CITY OF ALBUQUERQUE

Planning Department
Suzanne Lubar, Director

**RE: Lot 2 Block 9 Unit 22 Volcano Cliffs Subd.
6440 Picardia Pl NW NW
Request for Permanent C.O. - Accepted
Engineers Stamp Date 2/9/16 (D10D003B23)
Certification Dated: 7/12/16 Q2**

GRADING AND DRAINAGE PLAN
LOT 2, BLOCK 9, UNIT 22, VCS
ADDRESS: 6440 PICARDIA PL, NW.

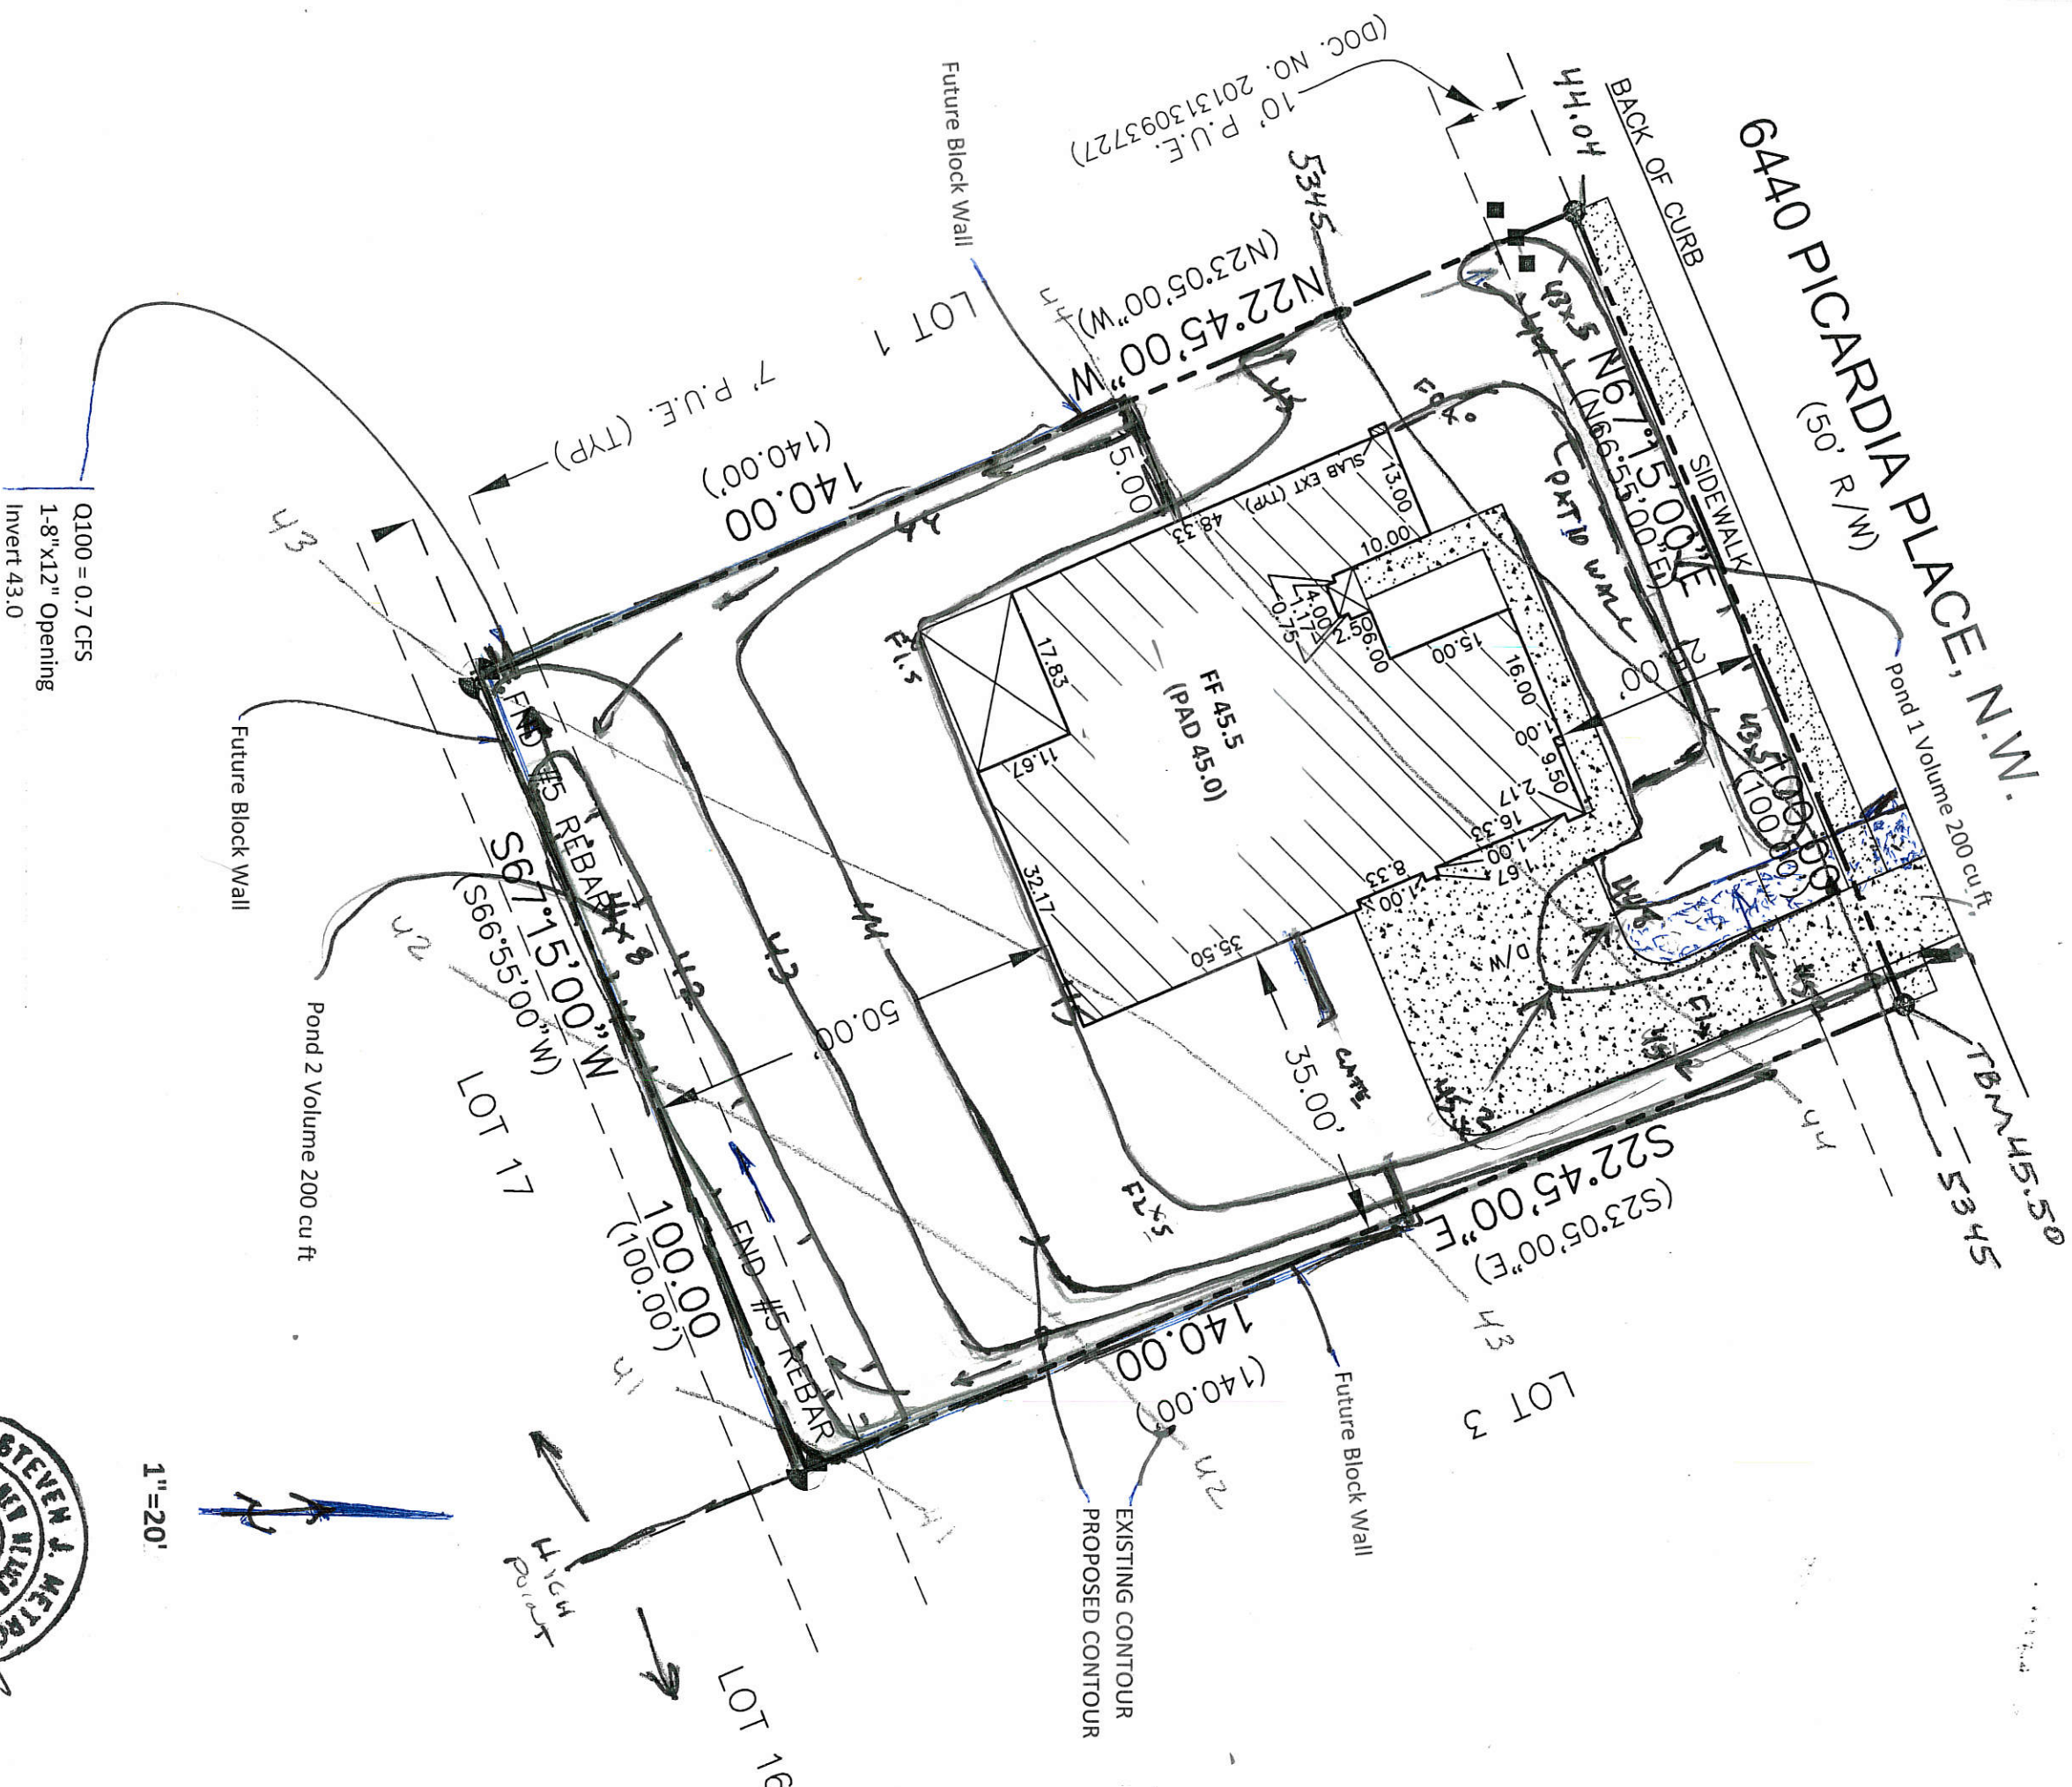
Based on the Certification received 7/19/2016, the above mentioned residence is acceptable for release of Certificate of Occupancy by Hydrology. It appears the front pond was treated with seeding/slope protection which will suffice for release of Certification of Occupancy. Landscaping for all ponds should be completed within 90 days.
